Responses by Preston Farms Ltd. and TCS Biosciences Ltd. to points raised in the Examining Authority's written questions dated 2.4.26 (deadline for response 22.4.26)

Preston Farms Ltd.
TCS Biosciences Ltd.

(submitted for them jointly by
Richard Buxton Solicitors, 22.4.26)

DOCUMENT:
 ENVIRONMENTAL STATEMENT
 VOLUME 3: FIGURES
 REGULATION 5(2)(a)

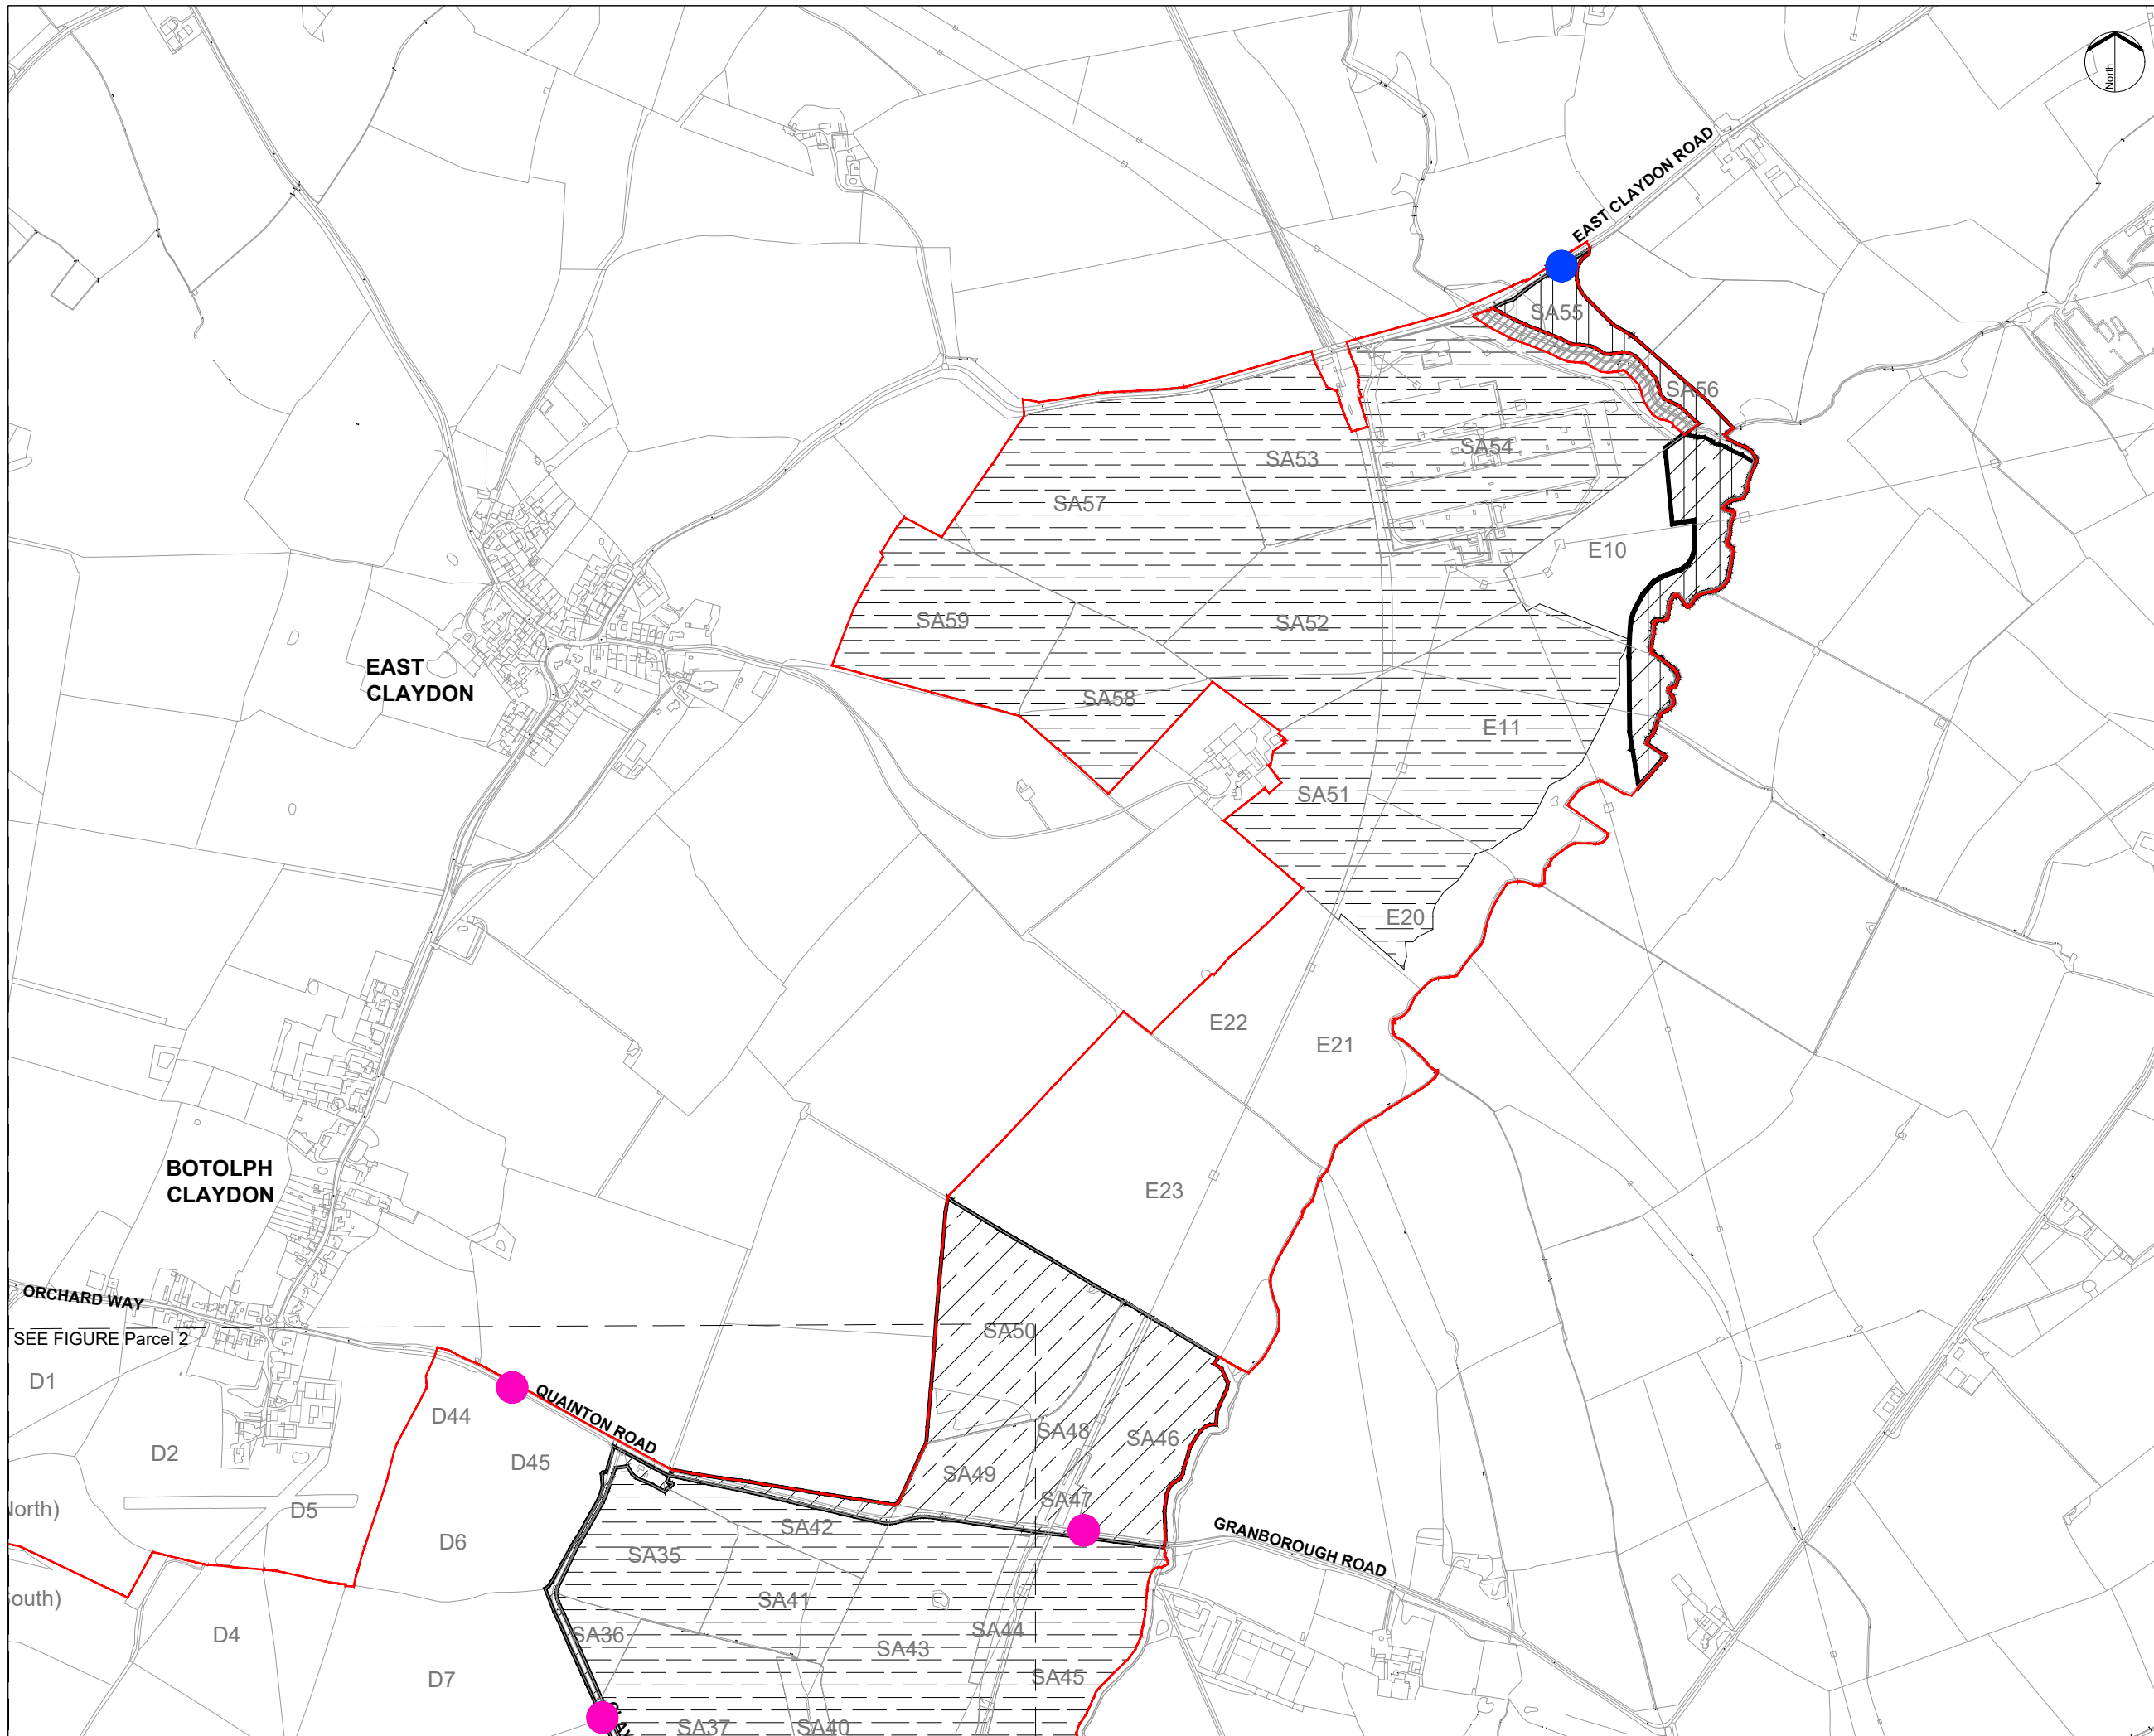
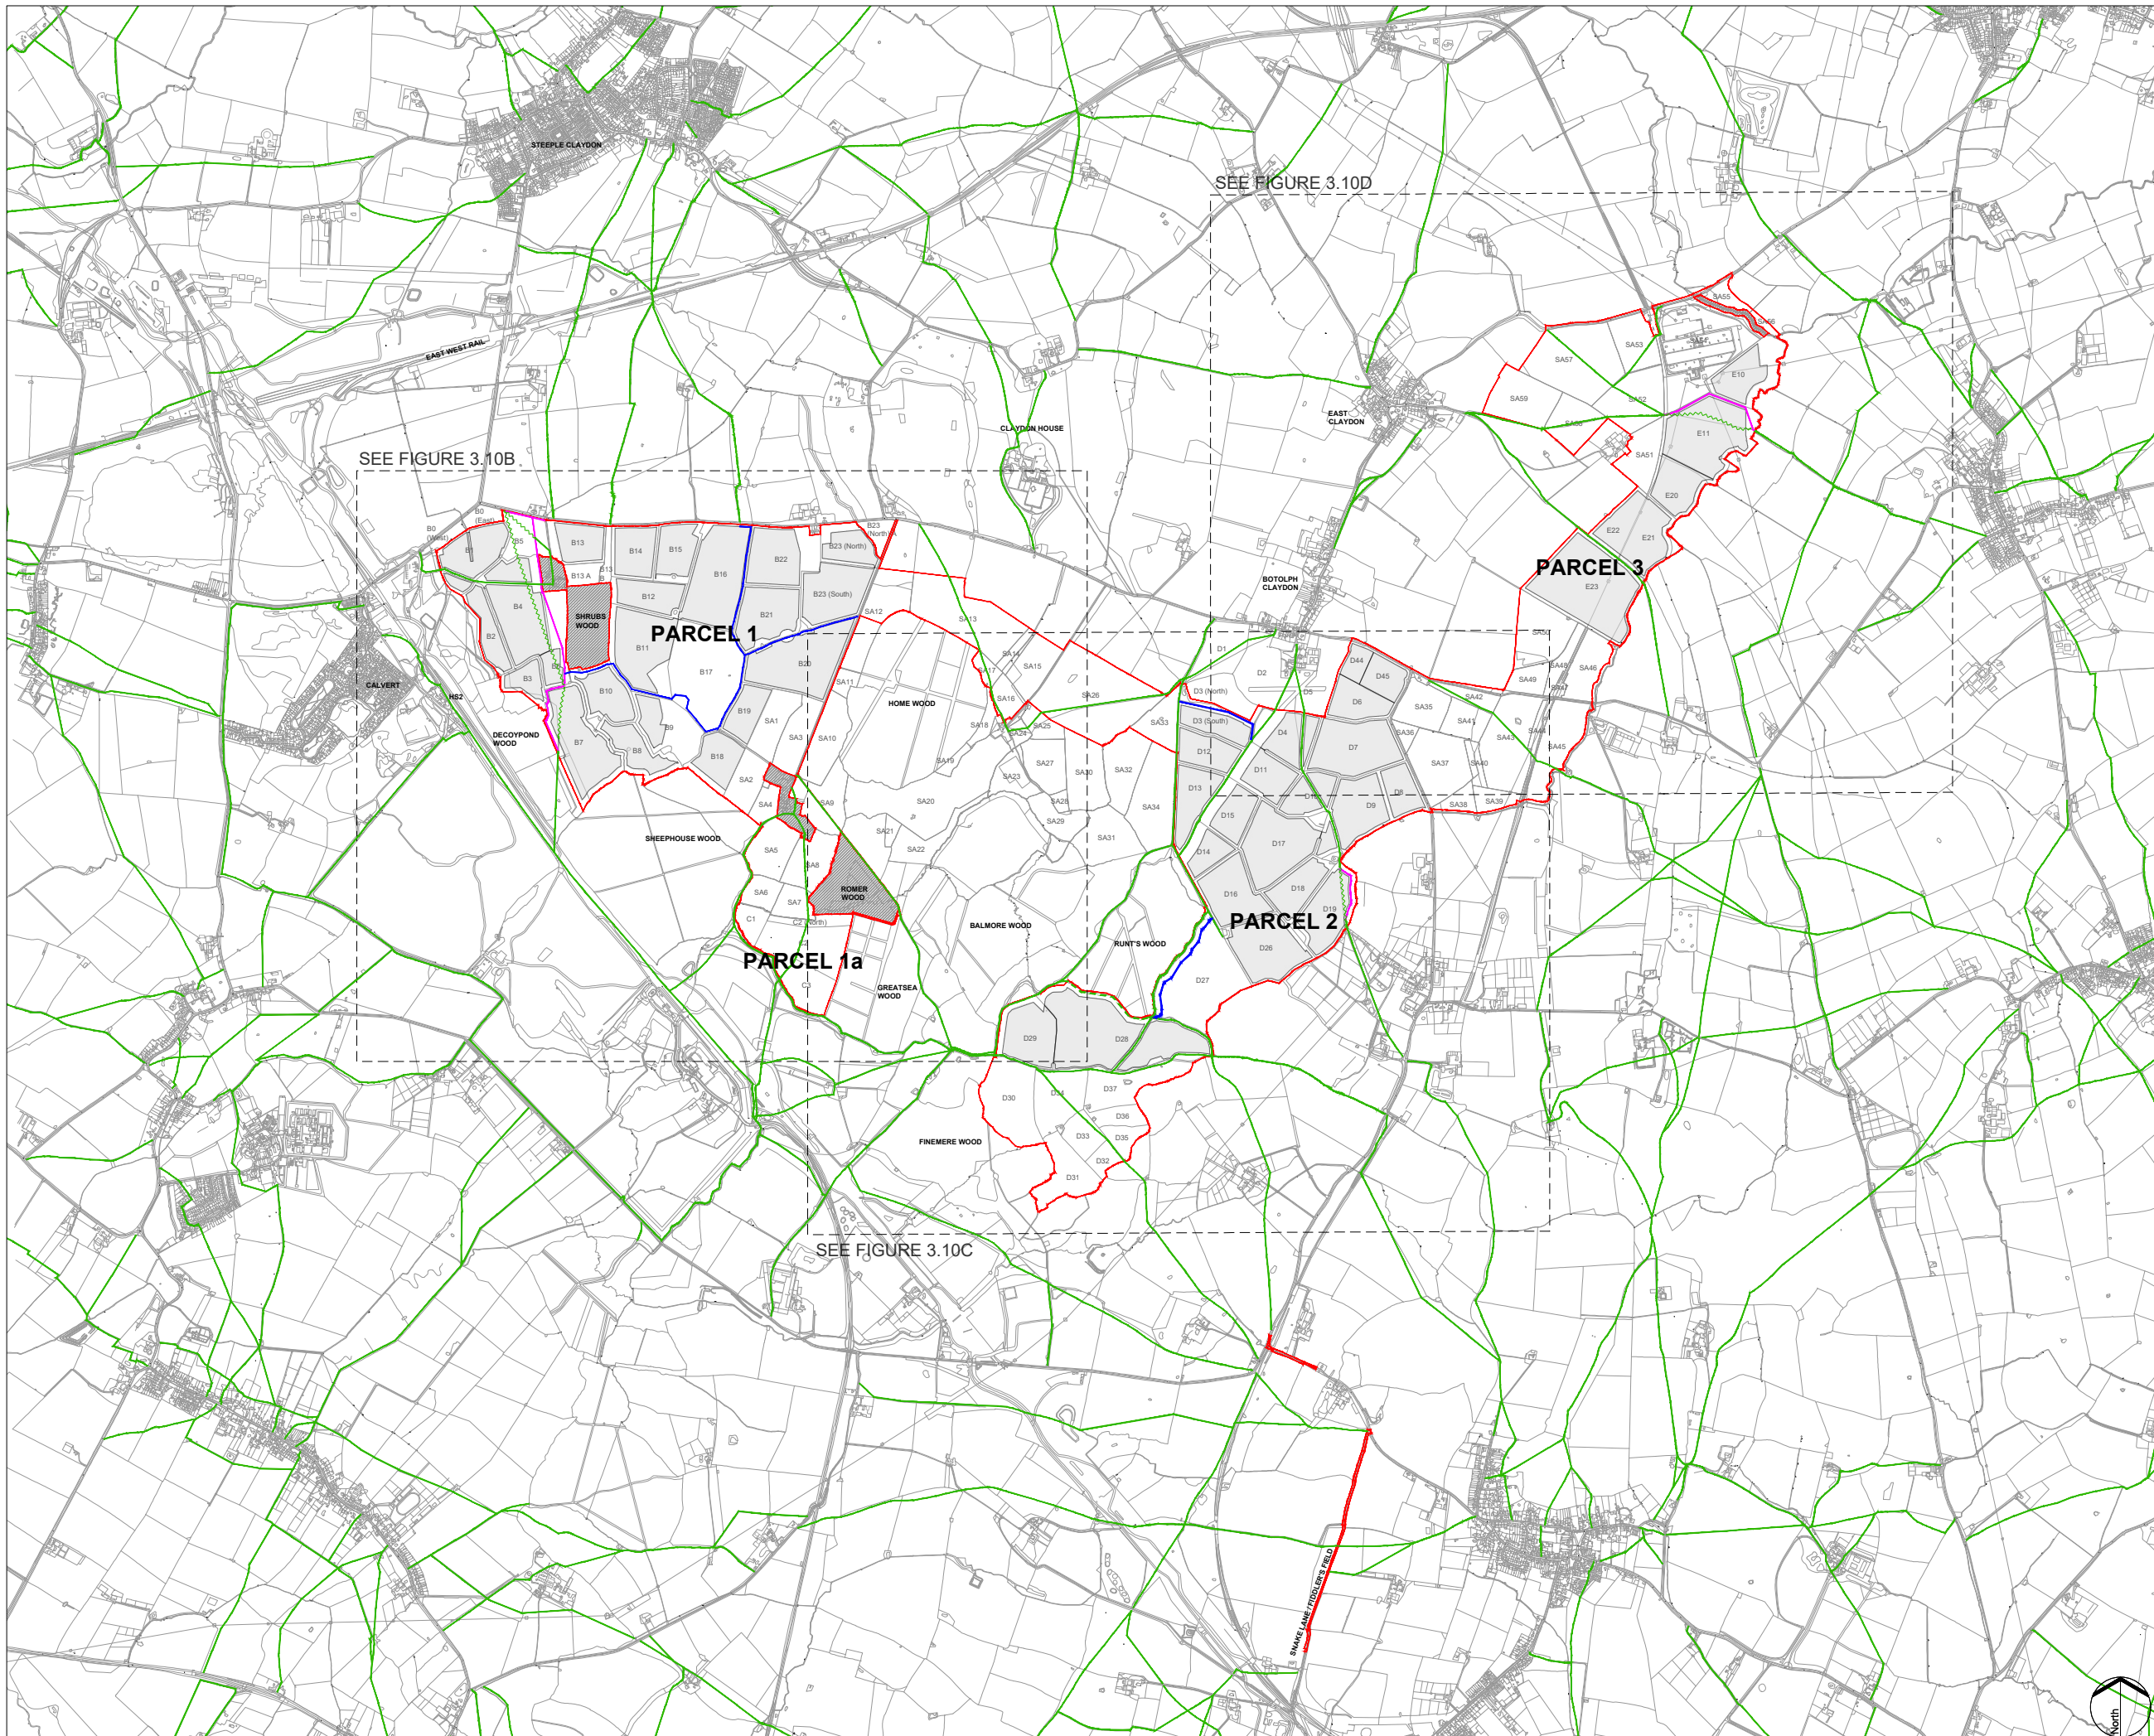
13. PFL and TCS submit that the Applicant's updated Outline Construction Environmental Management Plan [REP1-078], Outline Operational Environmental Management Plan [REP1-080] and Outline Decommissioning Environmental Management Plan [REP1-082] do not adequately address our concerns regarding mitigation measures or monitoring for noise.
14. A central unresolved point is that many of our construction phase noise and disturbance concerns arise because the Applicant continues to proceed based on construction access via Granborough Road, while providing no clear explanation as to why access

from Winslow Road is not feasible (we note it is already being used for abnormal loads). We address this in further detail in response to **Q1.19.13** below.

concerns only to a limited extent. The additions concerning information sharing, liaison with agricultural interests, and the commitment that no construction traffic will travel east on Granborough Road are welcome as far as they go. However, they do not resolve the central problem, namely that the proposed construction route via Granborough Road remains critically problematic for the continued smooth operation of PFL and TCS.

36. As explained in the Written Representation, the proposed construction access route from Granborough Road passes through a key part of the operation and is not compatible with it. This is not a minor inconvenience. Granborough Road provides an important route between different parts of the holding and between the farm and the TCS laboratories in Botolph Claydon. Preston Farms and TCS Biosciences produce donor animal blood 52 weeks of the year which must move quickly around the site (via Granborough Road), and the operation depends upon regular, controlled and uninterrupted movement of staff, livestock, feed and machinery.

39. The amendments to the oCTMP do not answer the prior question of why Granborough Road must be used at all. We have seen or heard nothing from the Applicant as to why access from Winslow Road is not feasible, other than a reference to “commitments” said to prevent that. No clear detail has been provided as to the nature of those commitments or to whom they were given. The Winslow Road is the access option for construction of numerous other infrastructure projects, such as the redevelopment of

the National Grid substation, Stratkraft BESS, Stratera BESS, and Tuckey Solar Farm and so we cannot see any barriers to using that route for the Applicant. The Winslow Road access is just near the north of Parcel 3 where the main Rosefield infrastructure is and it would alleviate many of our concerns about the crossing of our holding except in relation to required cabling. Likewise, no good reason has been given for the need for a permanent maintenance route across the Preston Farms holding after construction. If operational traffic is said to be very limited, that only further raises the question why ongoing access cannot be taken by a less harmful route.
